File No: R/2014/27
Your Ref: SSD 6371

RE: SSD 6371 – 175-177 Cleveland Street, Redfern

I refer to your correspondence received on 8 July 2014, inviting Council to make a submission regarding the proposal for a mixed use development at 175-177 Cleveland Street, Redfern.

SECTION AA @ 1:200

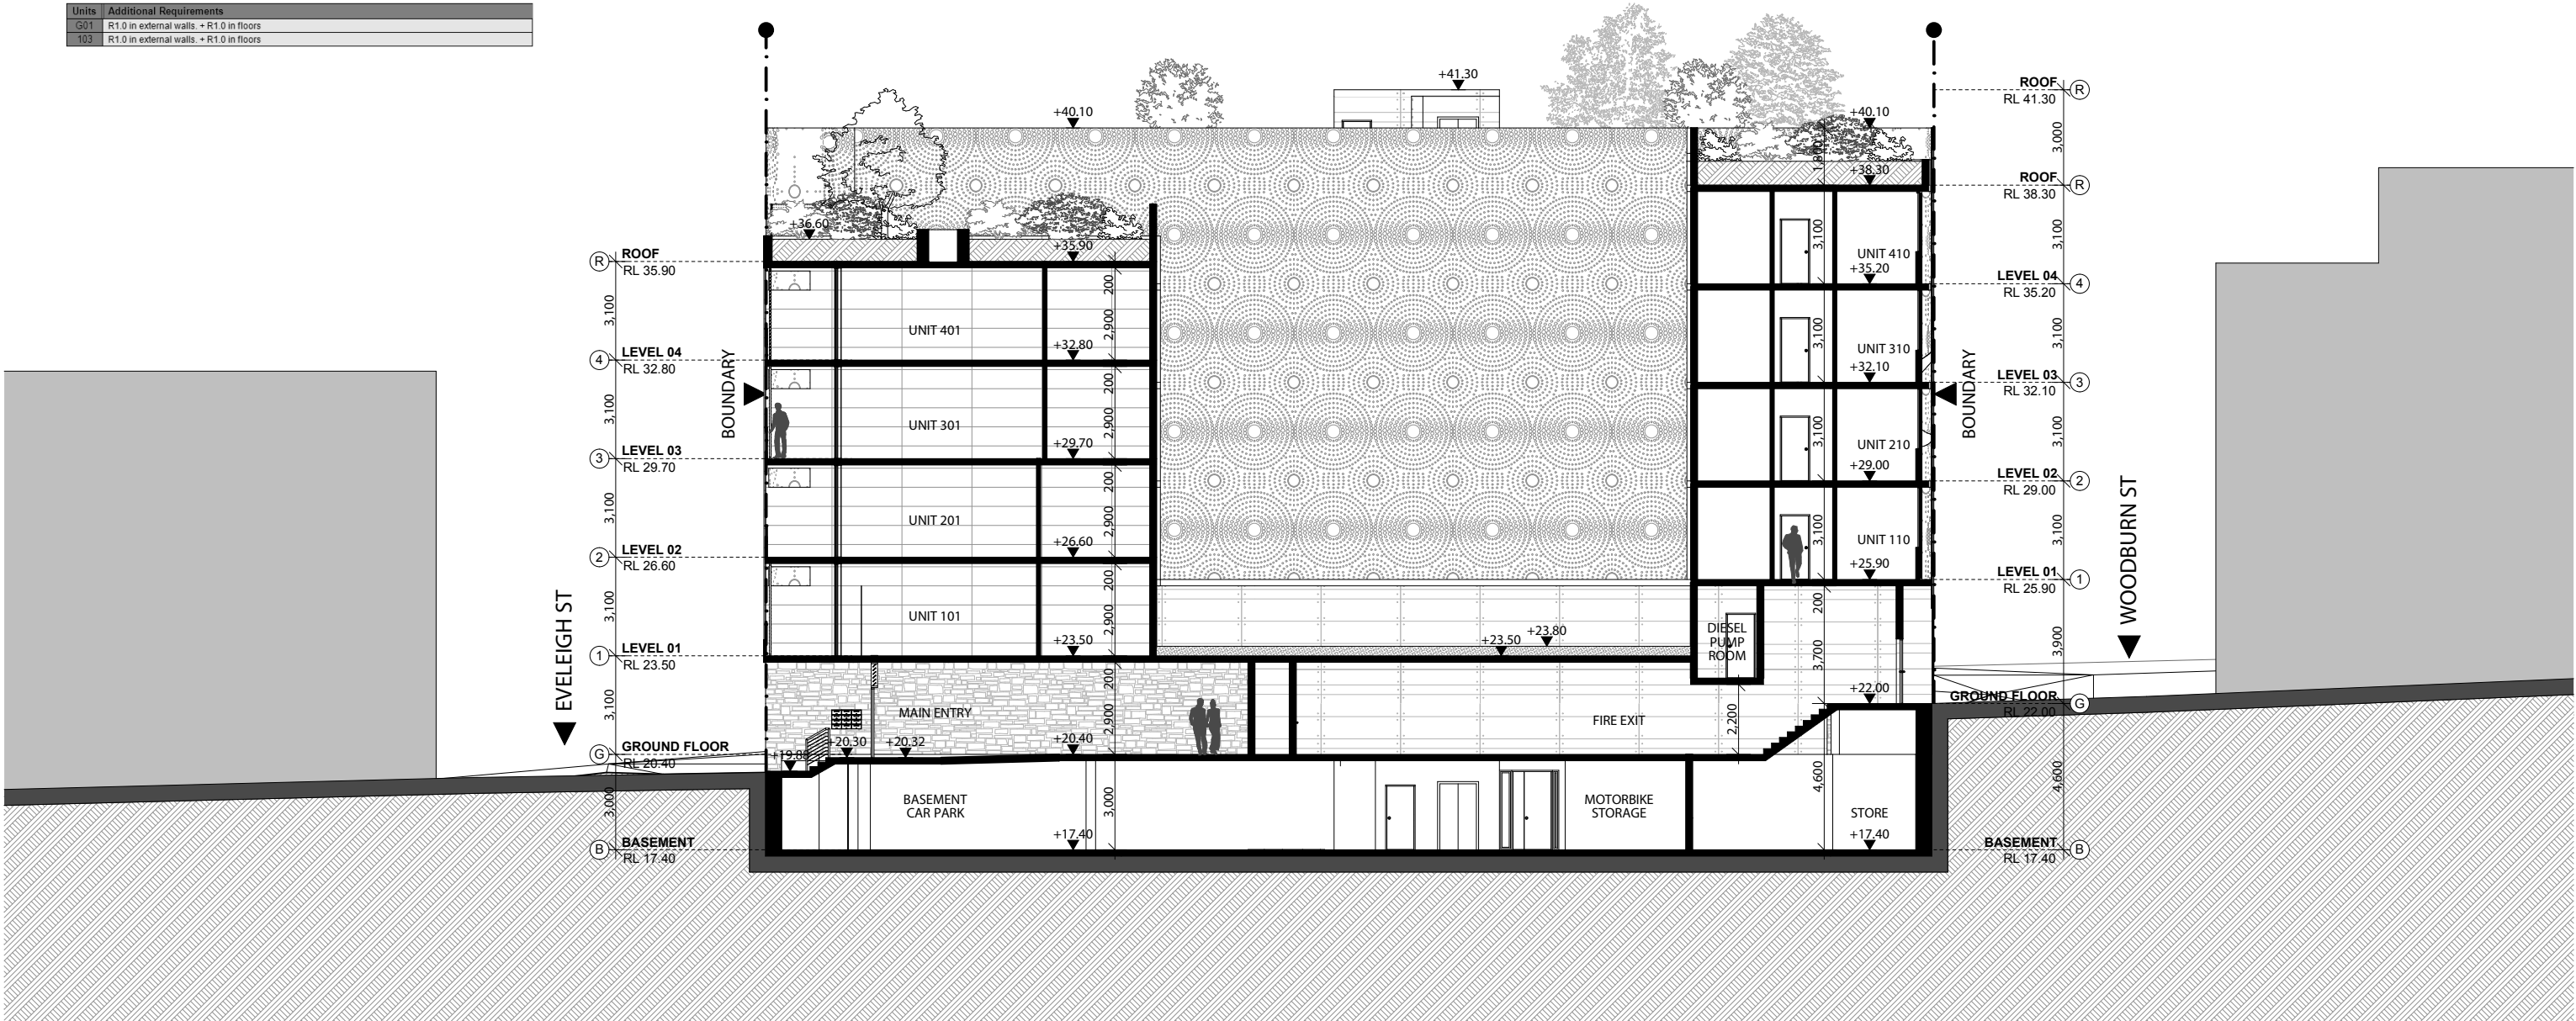
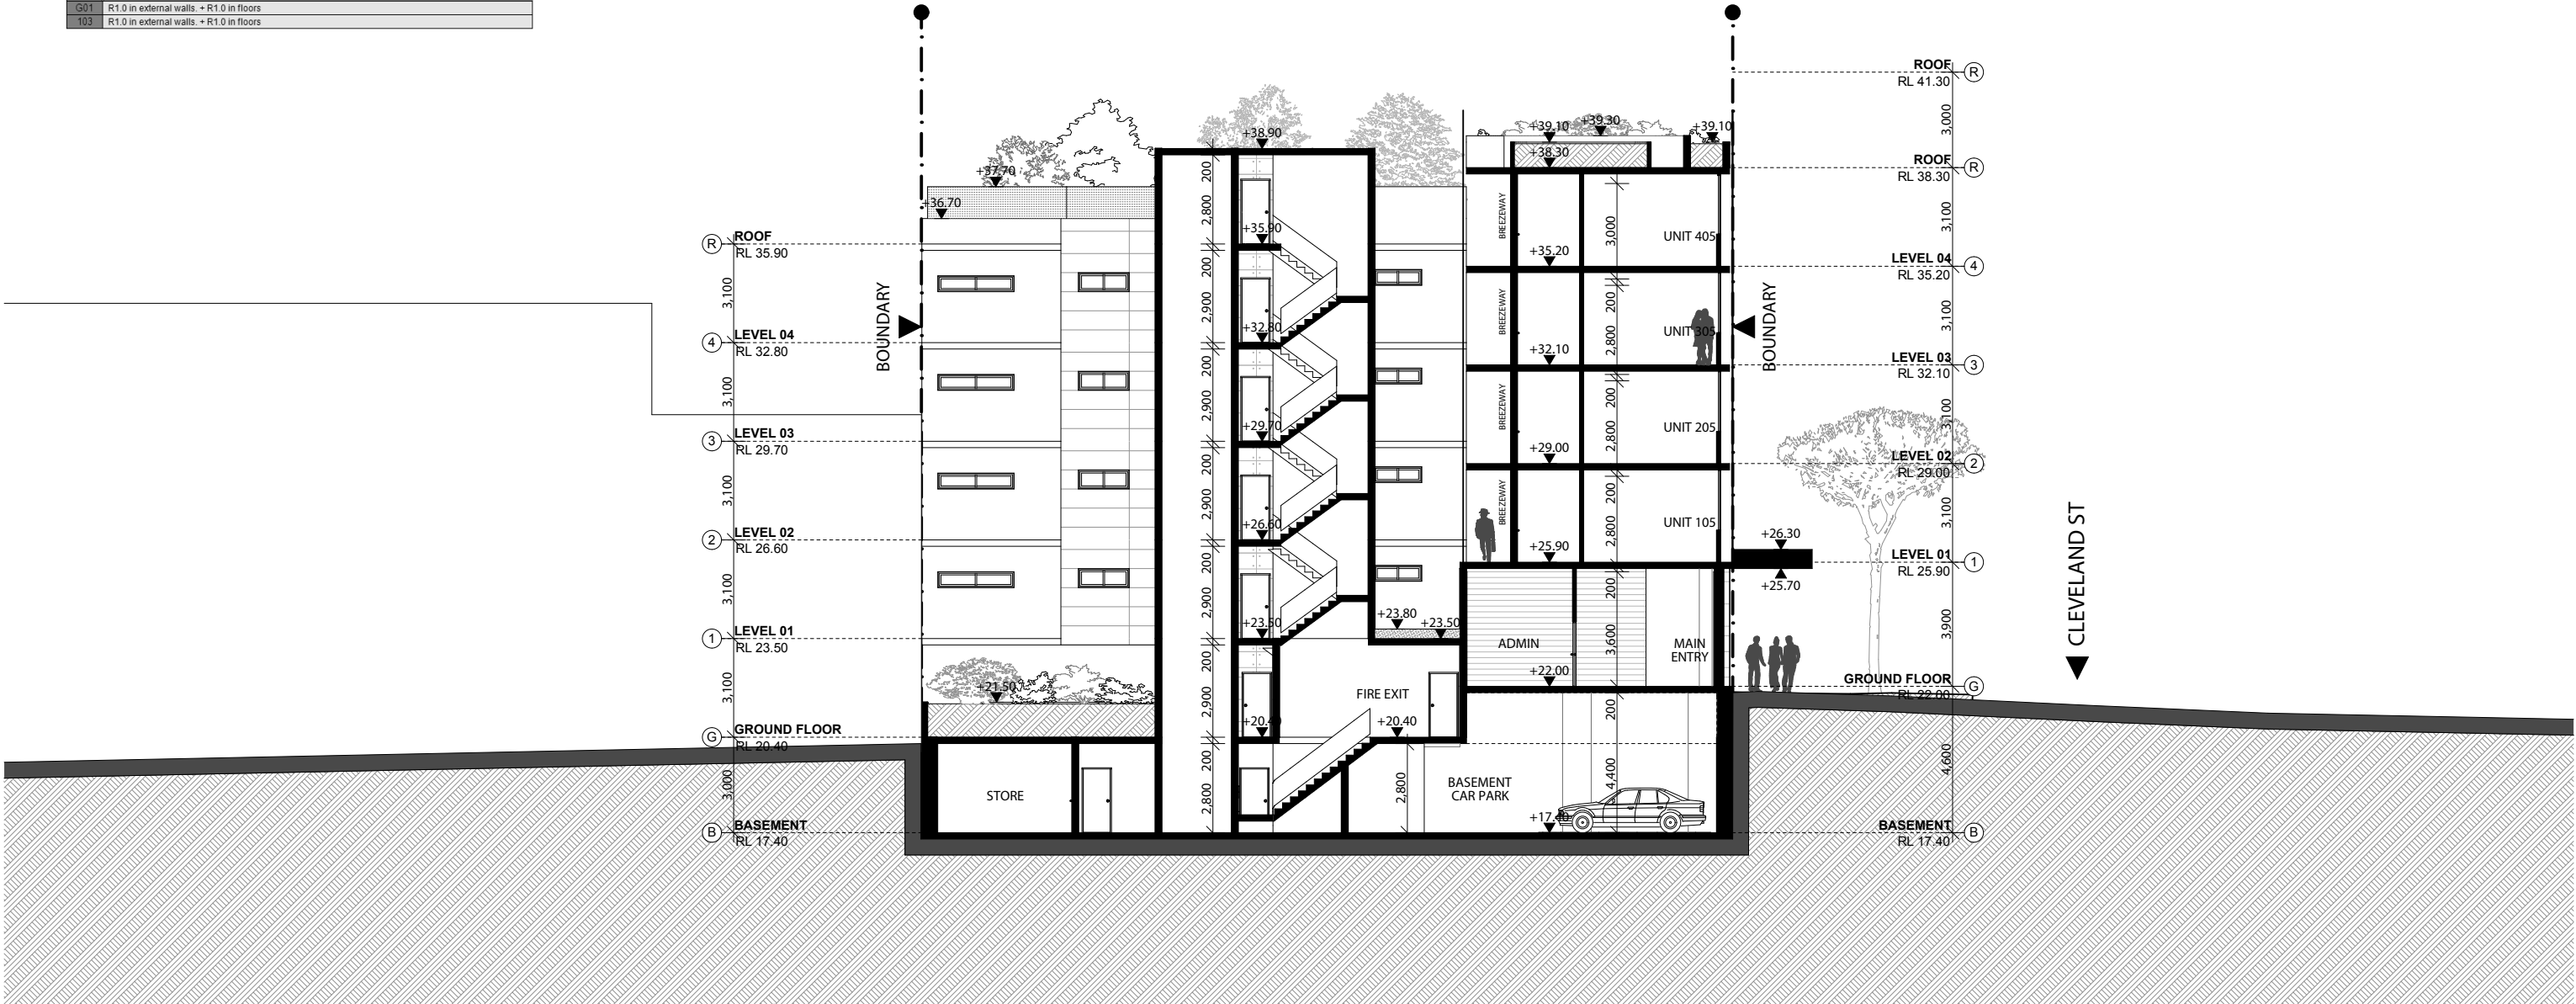
Sections provided show floor to floor heights of 3m. A floor to ceiling height of 2.7m requires a minimum floor to floor height of 3.1m. Further, the sections do not show the standard step down from the finished floor level to the slab, indicating that additional height may be required.
